21 November 2024

RJC:24-209

**Re: State Significant Development SSD-42425537 (“the SSD”);
Alterations and additions to Waverley College including demolition works,
refurbished Centenary Building, library extension, construction of a new 6
storey building, new sports facilities and ancillary works (“the proposal”);
Waverley College, 131 Birrell Street, Waverley (“the development site”)**

**FIGURE 3A**  
Aerial Photo – Detail

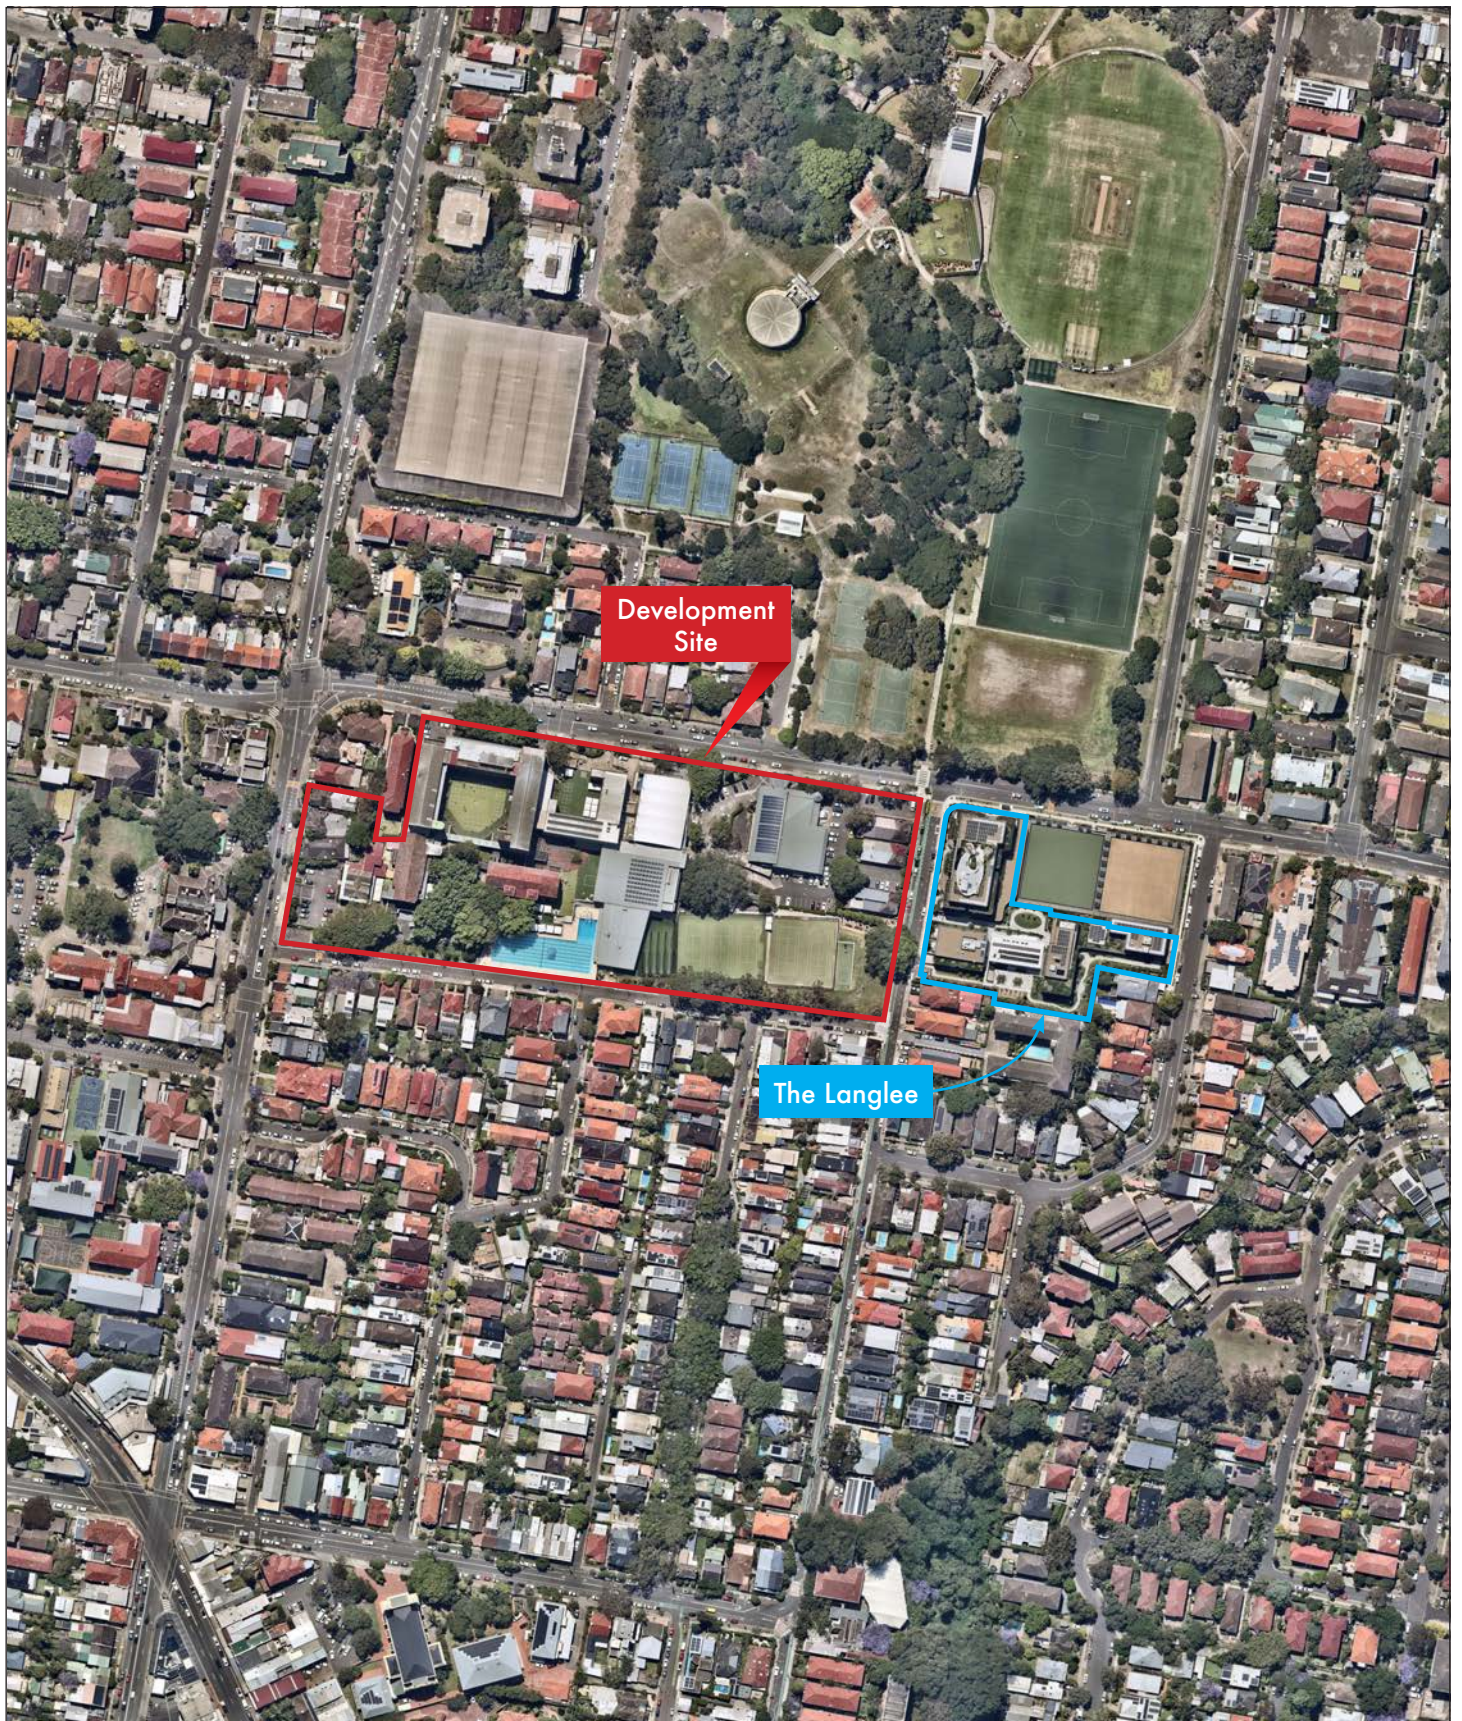
The relationship of The Langlee to the development site (see **Figures 2 and 3A**) is thus one where two of its buildings, 'Palmerston' and 'Glenroy', directly face towards the development site. In those two buildings there are 21 apartments which face towards and look out on the development site. All of the apartments in The Langlee are occupied by seniors, including a number who have a disability and/or have impaired mobility, and most of whom are retired or semi-retired so are much more likely than not to be at home during the day and therefore more prone to affectation from construction impacts than residents of non-seniors housing.

**FIGURE 3B**  
Aerial Photo – Surrounding Context

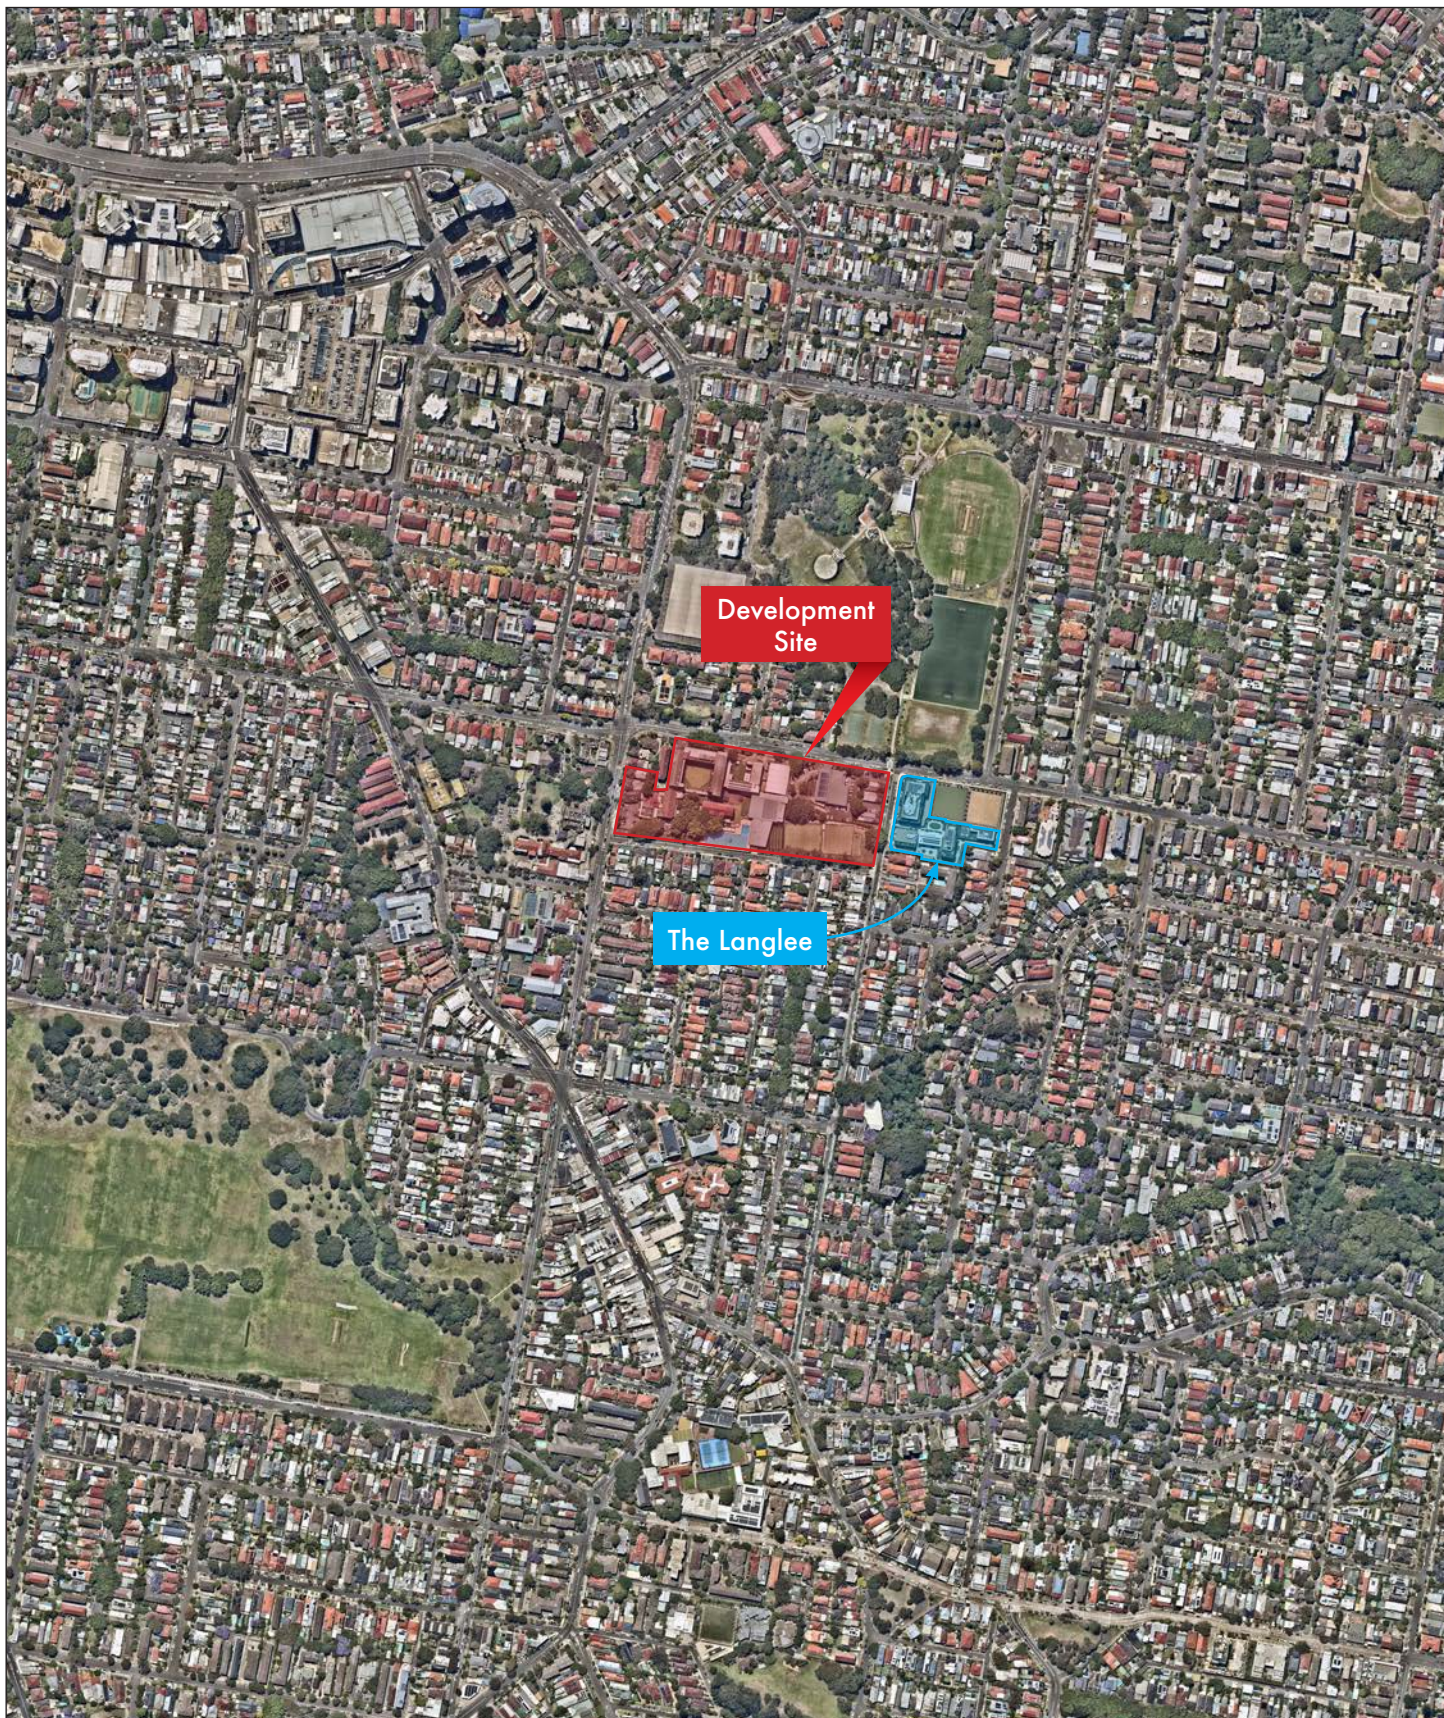
The notion that the western side of Henrietta Street could become a Work Zone is of great concern to our client. Henrietta Street is a 'light traffic only' one way southbound street but with a northbound bicycle only lane. It is not suited to use as a work zone (even on a temporary basis). In this regard, the bicycle lane in Henrietta Street is linked to the cycle way which runs through Waverley Park. The photos overleaf show the bicycle way close to where it crosses Birrell Street. It can also be seen in the aerial photo in **Figure 3B**.

**FIGURE 4A**  
Zoning Map - Waverley LEP 2012

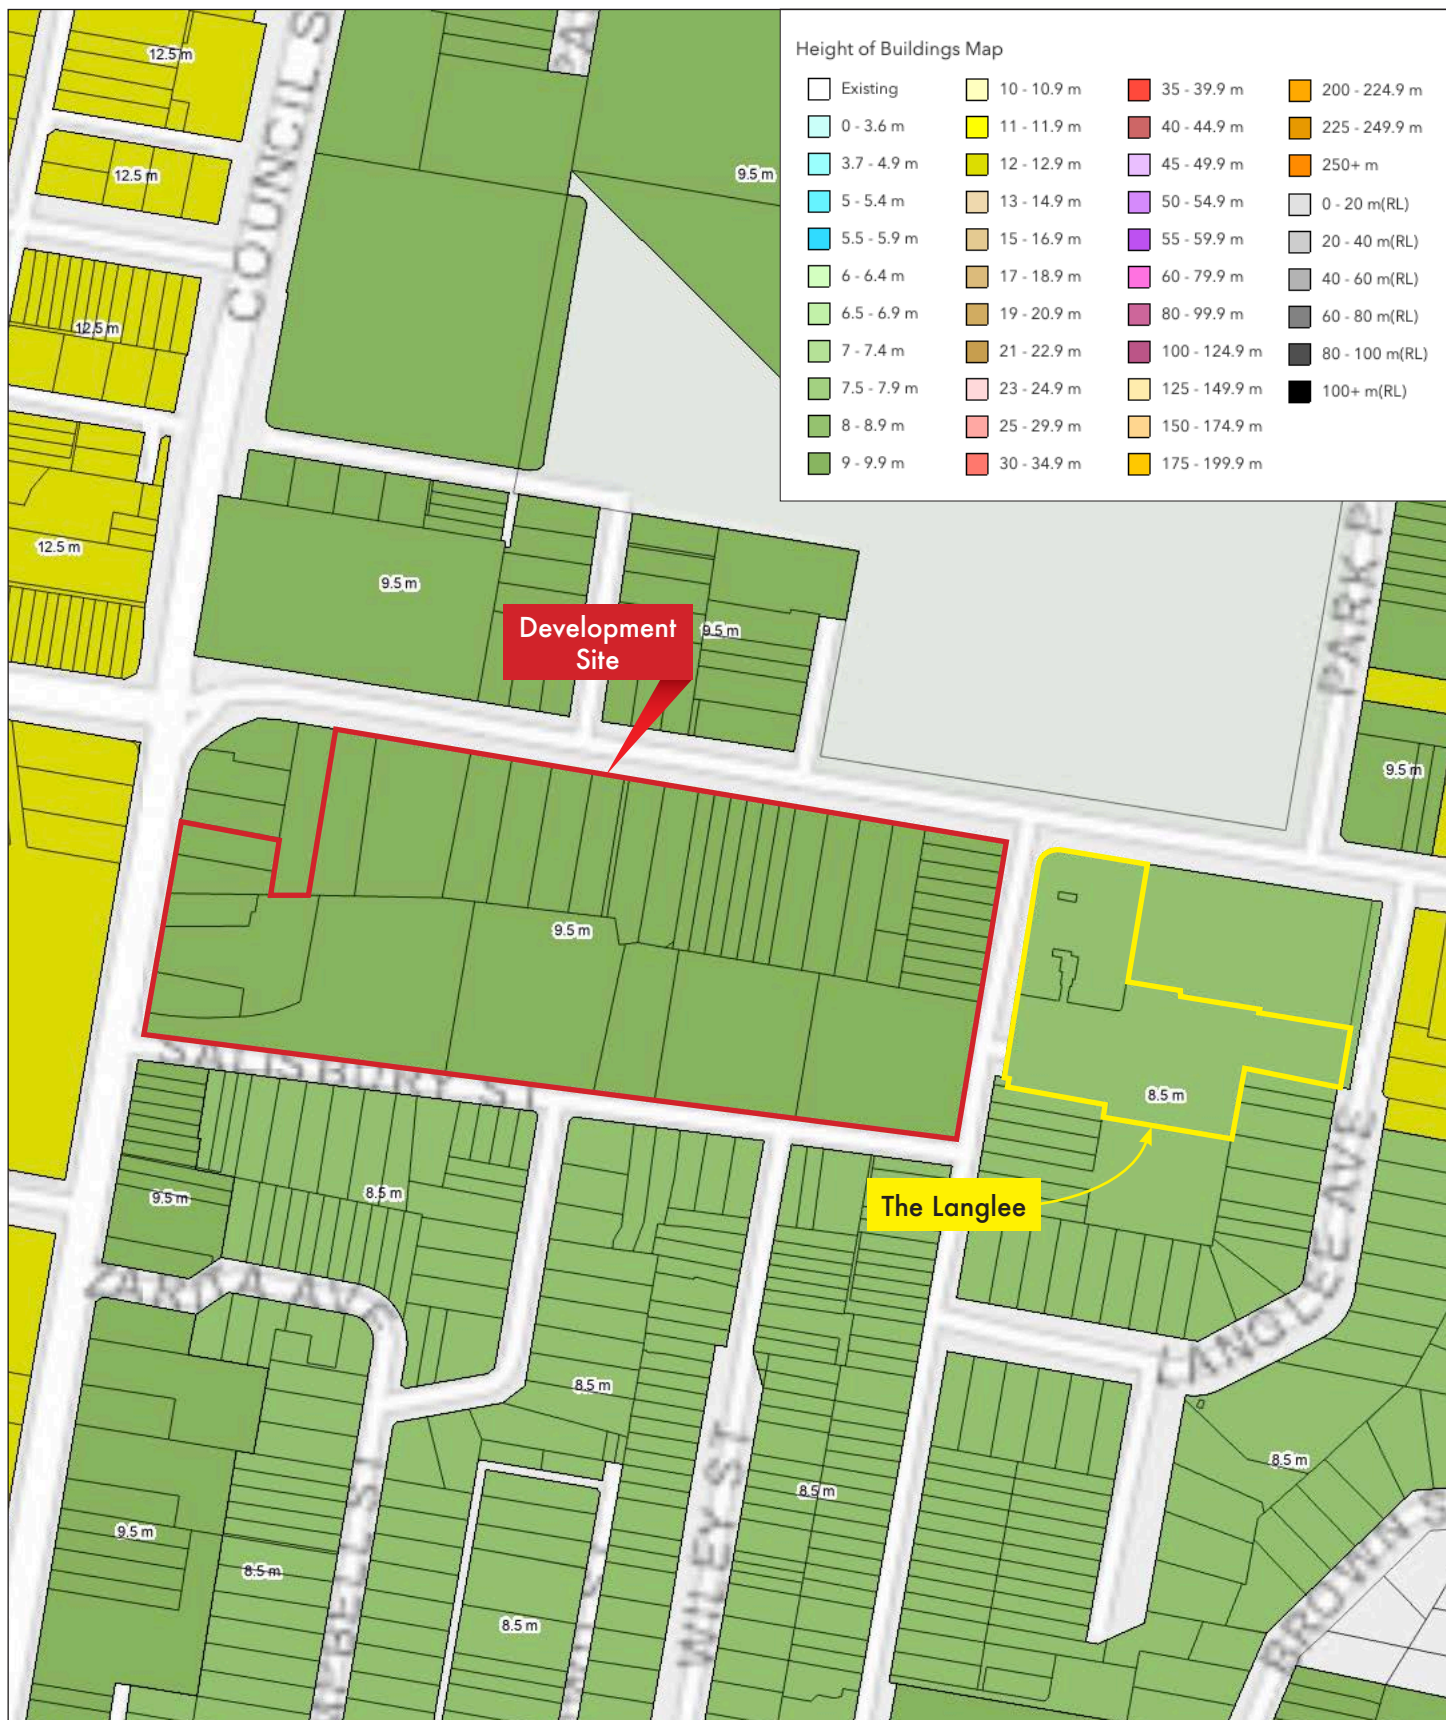
Reference to **Figure 4A** shows that Building 1 is predominantly on that part of the development site which is zoned R3 Medium Density Residential and reference to **Figure 4B** shows that the height limit applying to the site is 9.5m. Building 1 is also on that part of the development site which is identified as a heritage item (see **Figure 4D**). Notwithstanding these planning controls in Waverley LEP 2012, Building 1 has a proposed height in Stage 2 of 24.5m and will extend to within 4.353m of Henrietta Street. In Stage 2 it will have a length of around 75m and part of it will extend into the canopy of the Port Jackson Fig tree which is adjacent to Henrietta Street.

**FIGURE 4B**  
Height of Buildings Map – Waverley LEP 2012

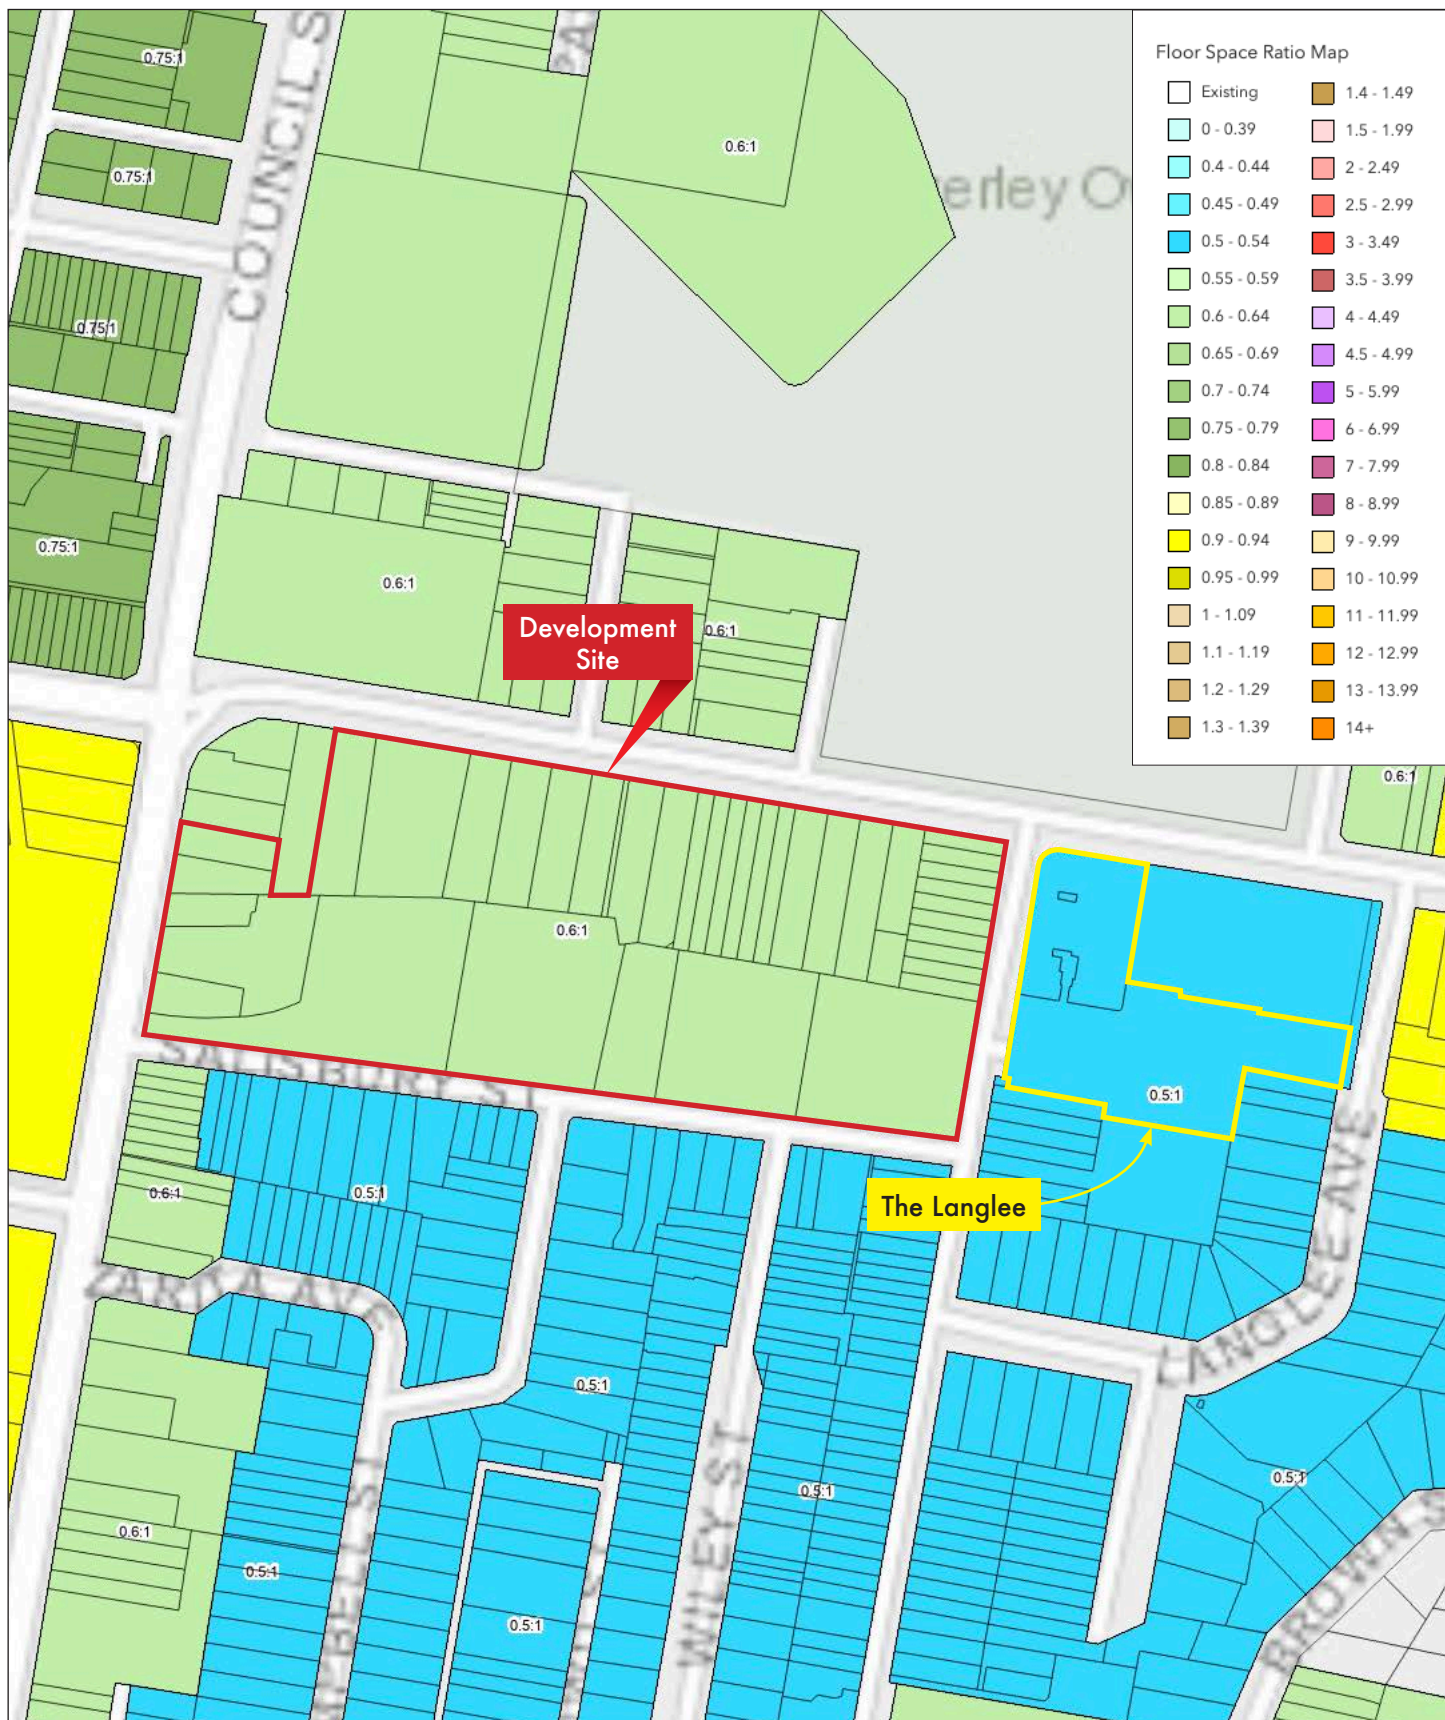
Whilst we acknowledge that pursuant to Section 3.43 of the Transport and Infrastructure SEPP, development consent may be granted even though the proposal contravenes a development standard in Waverley LEP 2012 (i.e. in this case, the 9.5m maximum height standard by 15m), the size of Building 1 in Stage 2 is excessive: it is too high, too long, too close to Henrietta Street and too close to the Port Jackson Fig tree. Building 1 should be limited to what is proposed in Stage 1.
